Contact: Kate MacDonald
Phone: 02 9228 6435
Fax: 02 9228 6540
Email: kate.macdonald@planning.nsw.gov.au
Our ref: MP11_0046

Stage 3 Residential Development 61 Mobbs Lane, Epping (MP11_0046)

Attachment A

SITE SECTIONS - 1

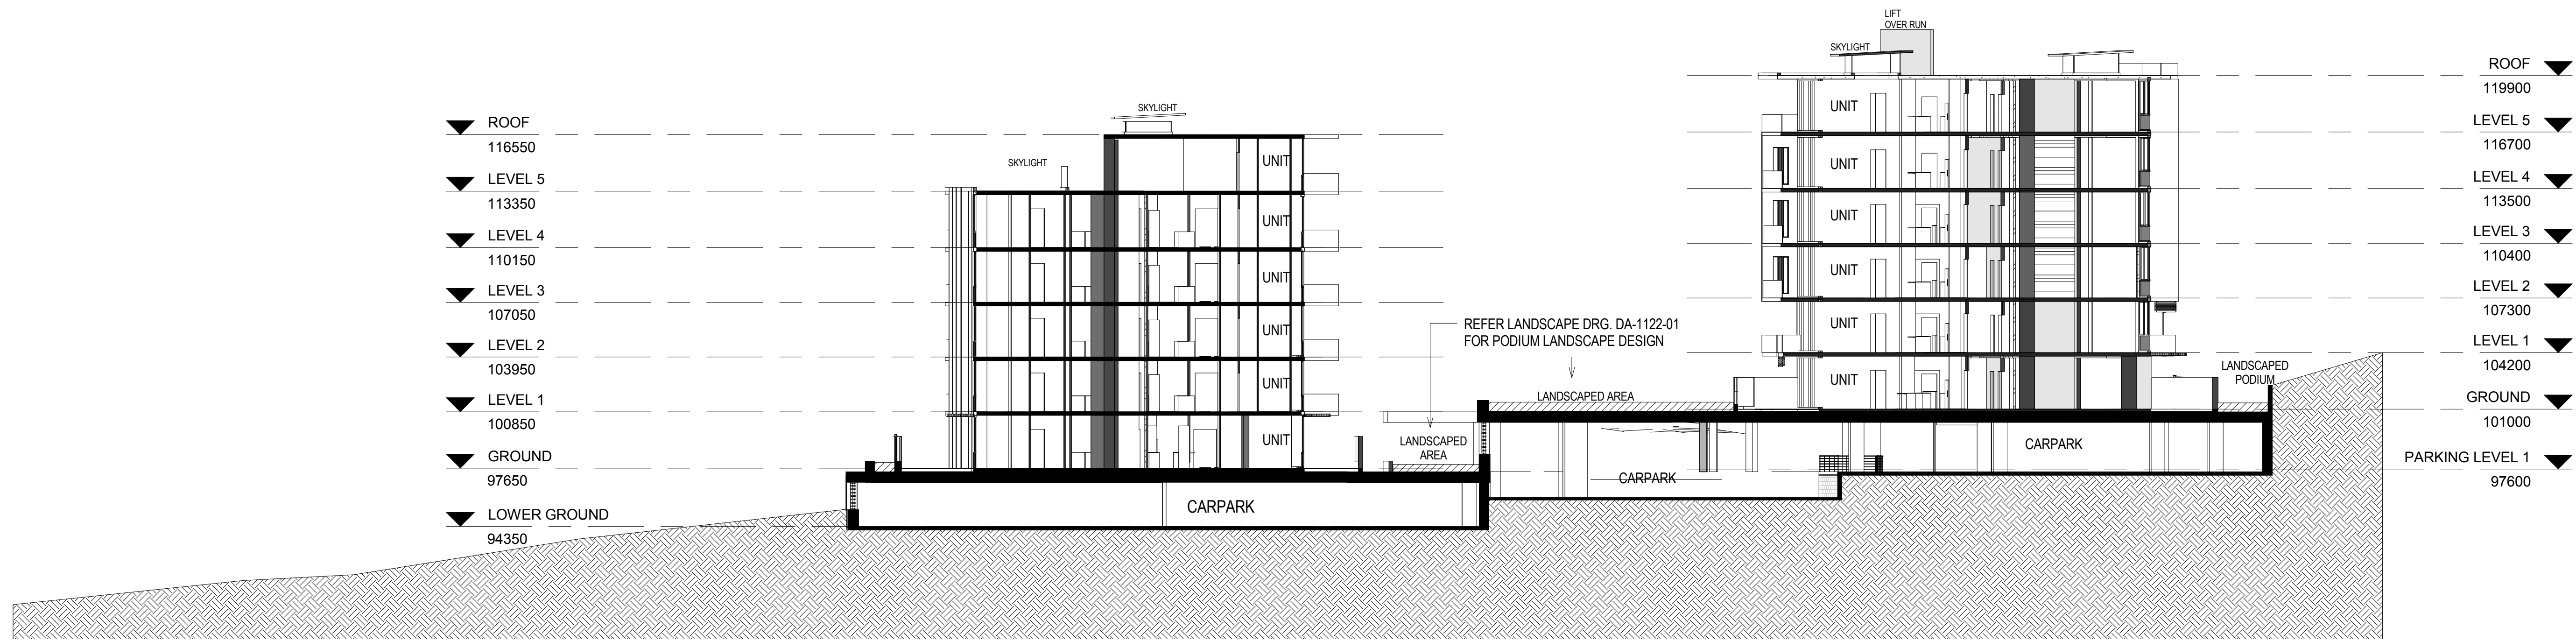
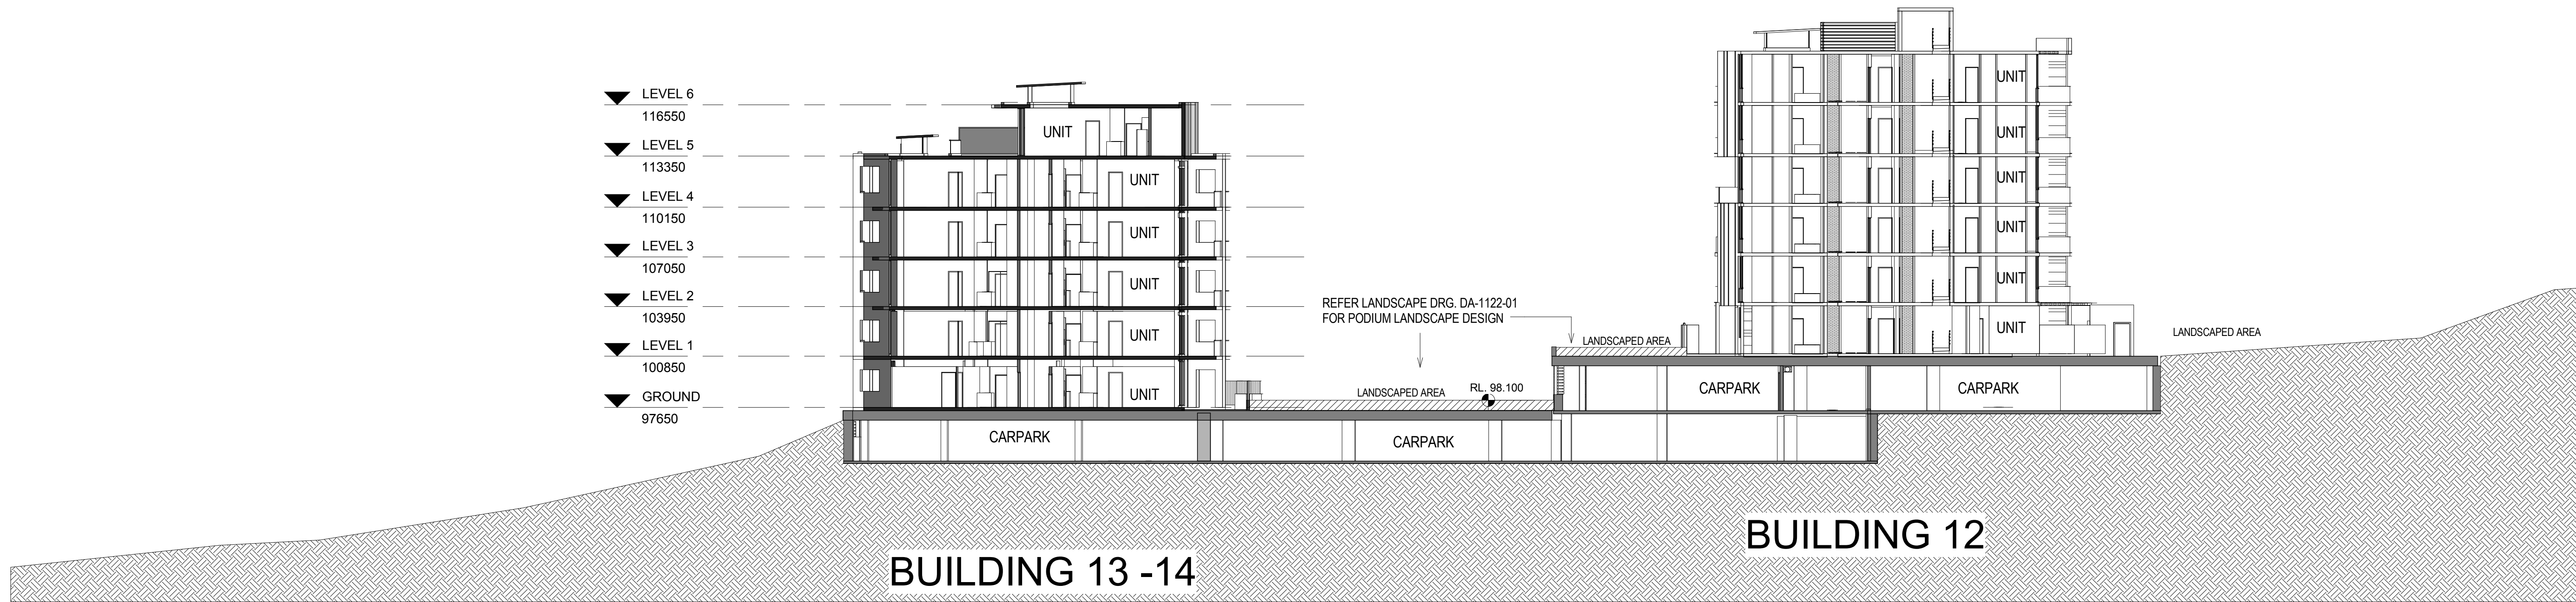
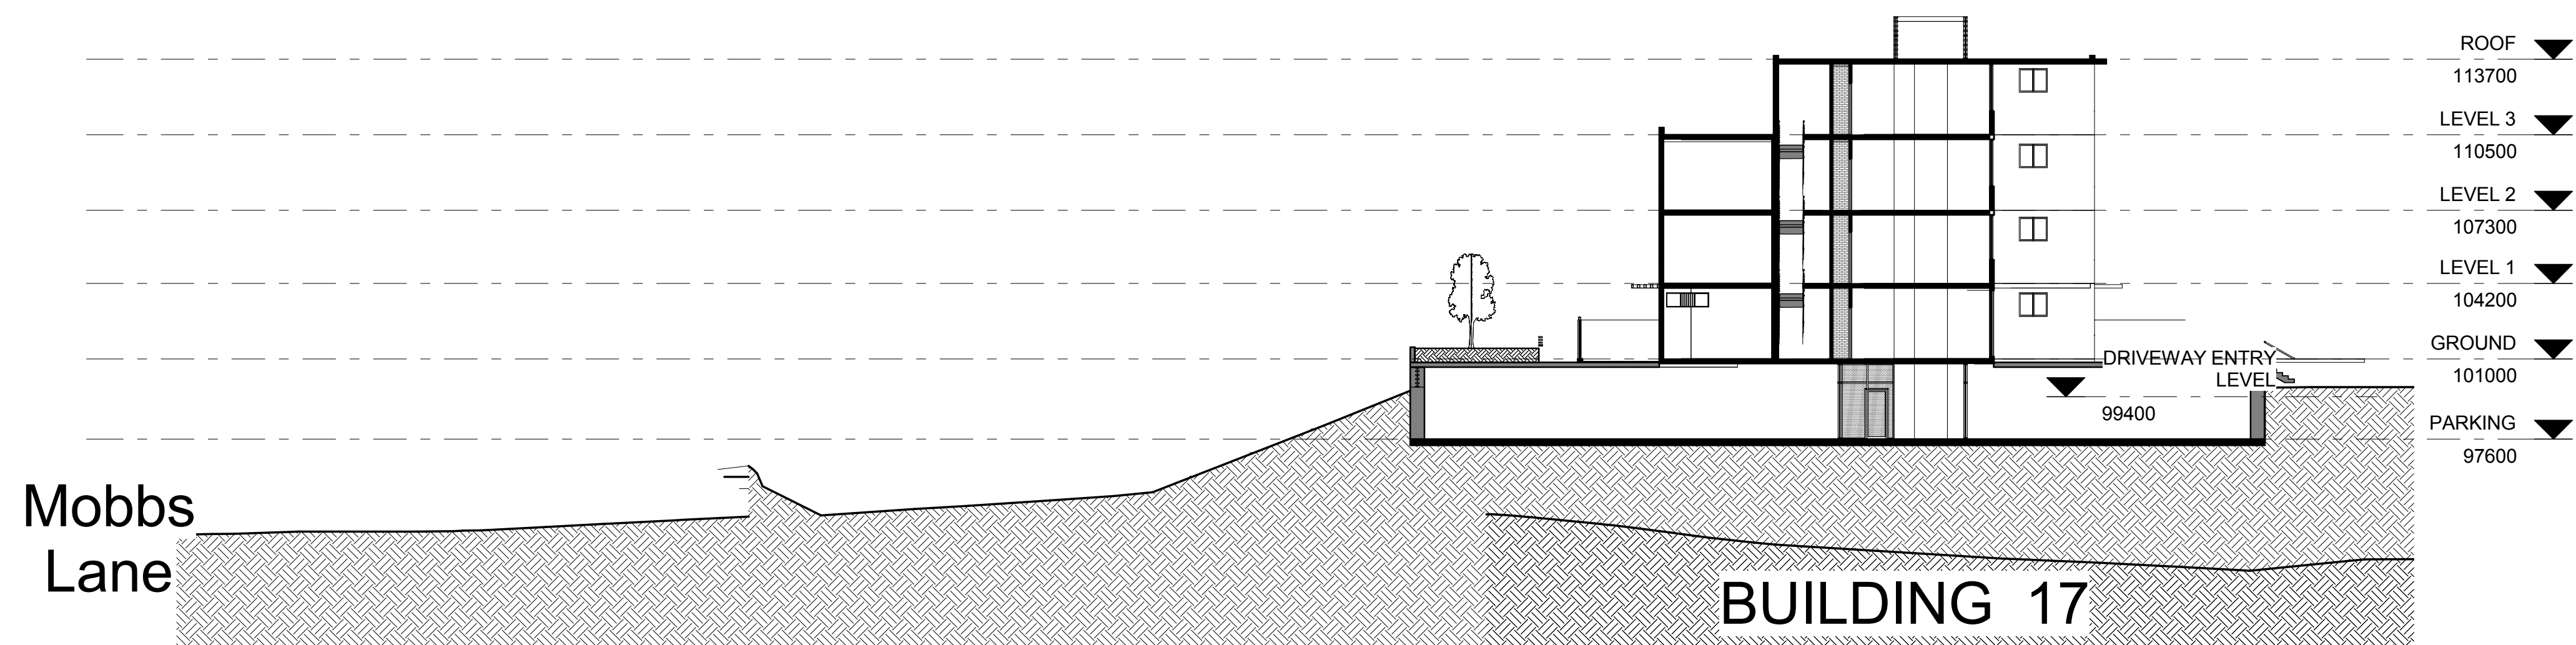
Concern is raised with the amendment to the Concept Plan footprint in relation to building 17. The height of this building and its proximity to Mobbs Lane is inappropriate and the building should be amended to comply with envelope specified in the approved Concept Plan.

Concern is raised with the height of various parking and podium elements, particularly in relation to the visual impact of such elements when viewed from open space areas and Mobbs Lane. This concern could potentially be addressed by landscaping (see section 1.5 below). Notwithstanding, the department considers that portions of building 17 are too close to Mobbs Lane, and the bulk and scale of the building can not be reduced via additional landscaping.

client: MERITON APARTMENTS  
**EPPING PARK STAGE 3  
BUILDING 17  
LANDSCAPE PLAN**

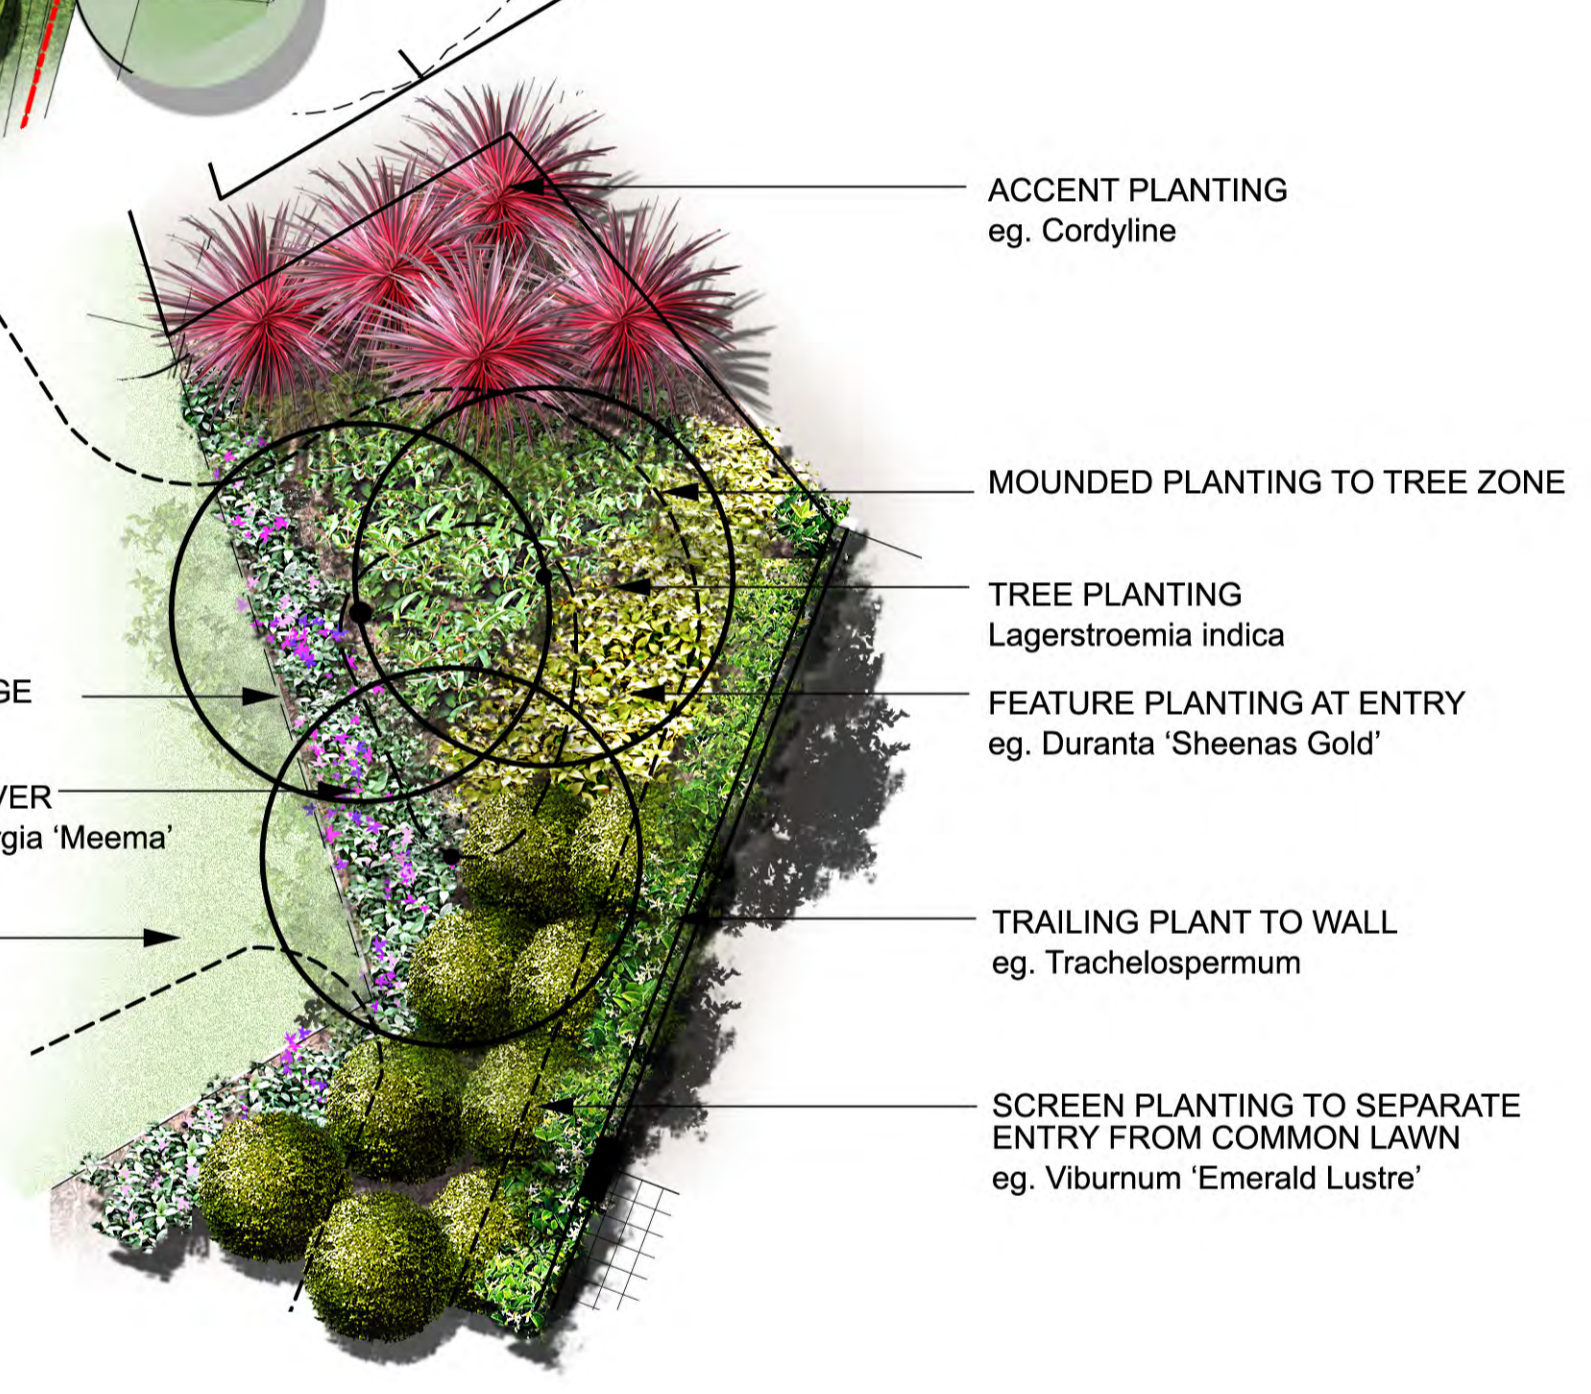
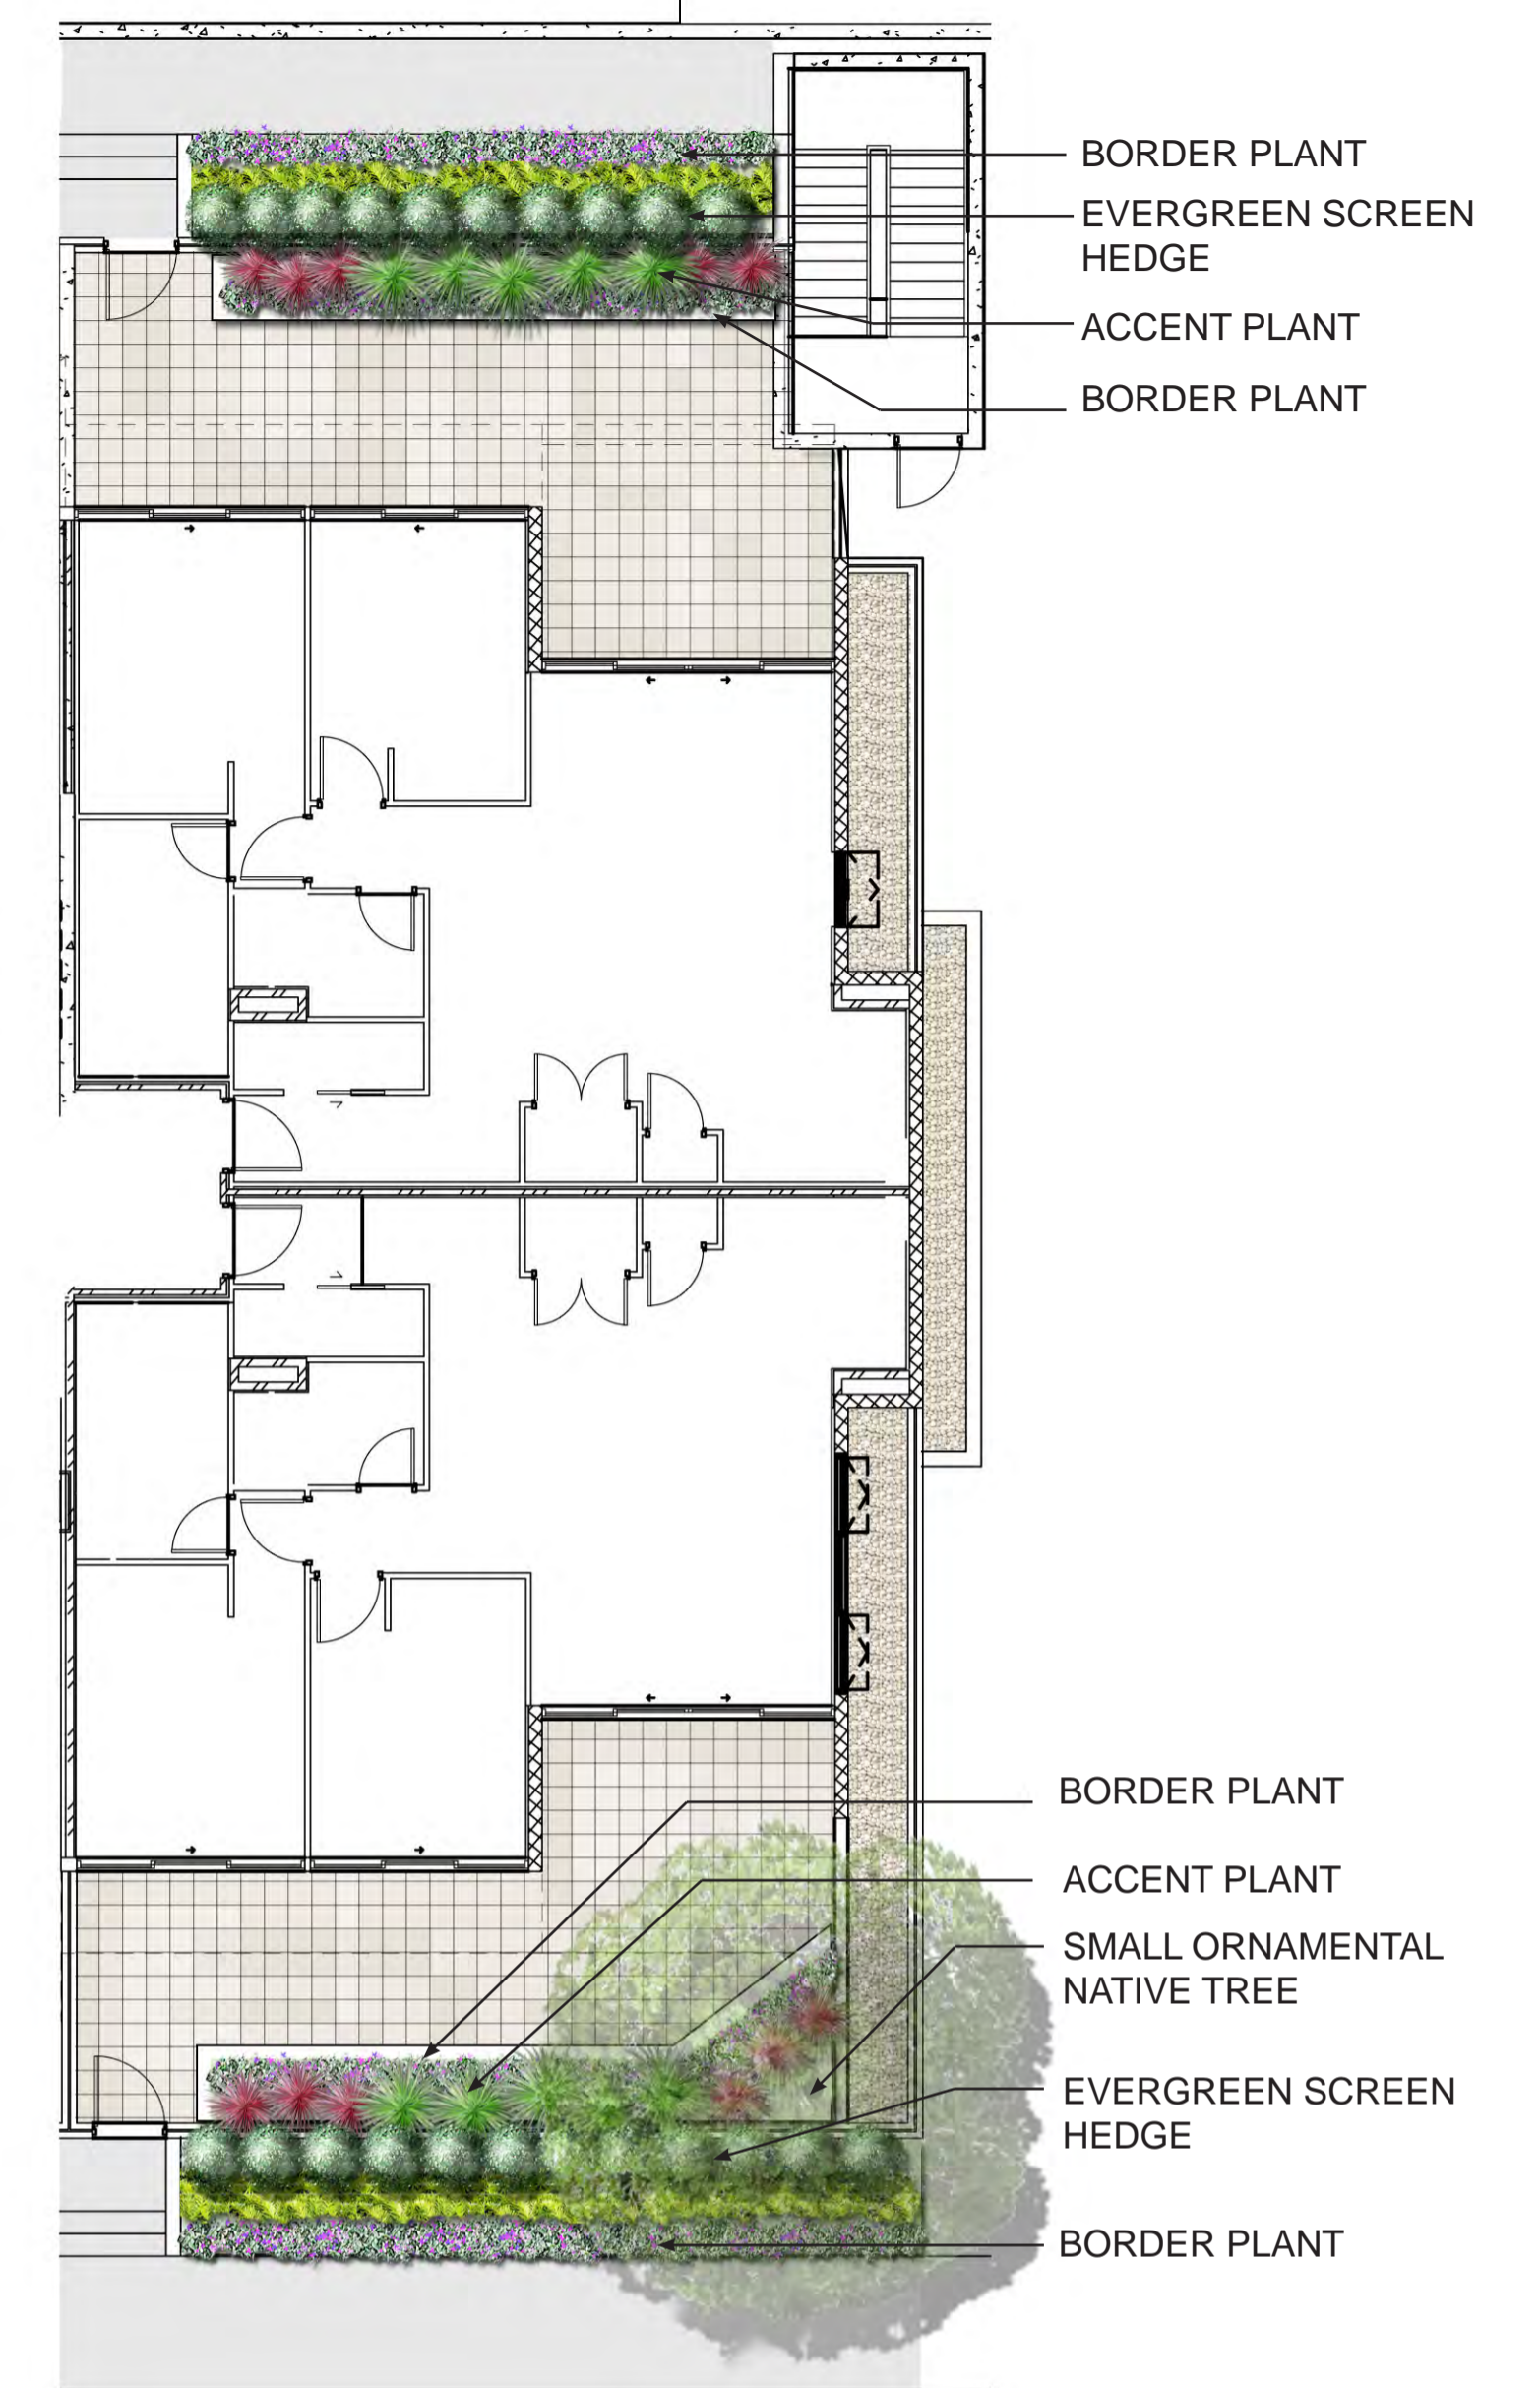
Detailed landscape plans should be provided which identify landscape treatments for all communal and public open space areas. The plans should provide a similar level of detail to drawing numbers EW-PA01, EW-PA03, EW-PA07, EW-PA08, EW-PA09 and EW-PA17 as originally approved under MP 08_0258. In addition, the plans should provide the following information:

- (a) the location of proposed ground covers, shrubs, hedges and small and canopy trees with an indicative species list for each category (to include mature specimen heights – specific to the site conditions);

- (c) planting is to be provided in the form of a dense hedge (or an equivalent screening element) adjacent to the above ground portions of the car park to ensure it is not visible from within the site, the publicly accessible open space, the adjacent reserve and residential properties, or Mobbs Lane;

- (d) the visual bulk of the buildings as viewed from the publicly accessible open space, the adjacent reserve, adjoining residential properties and Mobbs Lane is to be “softened” by the planting of a mixture of canopy and small trees in reasonable proximity to the edges of the podiums/buildings;
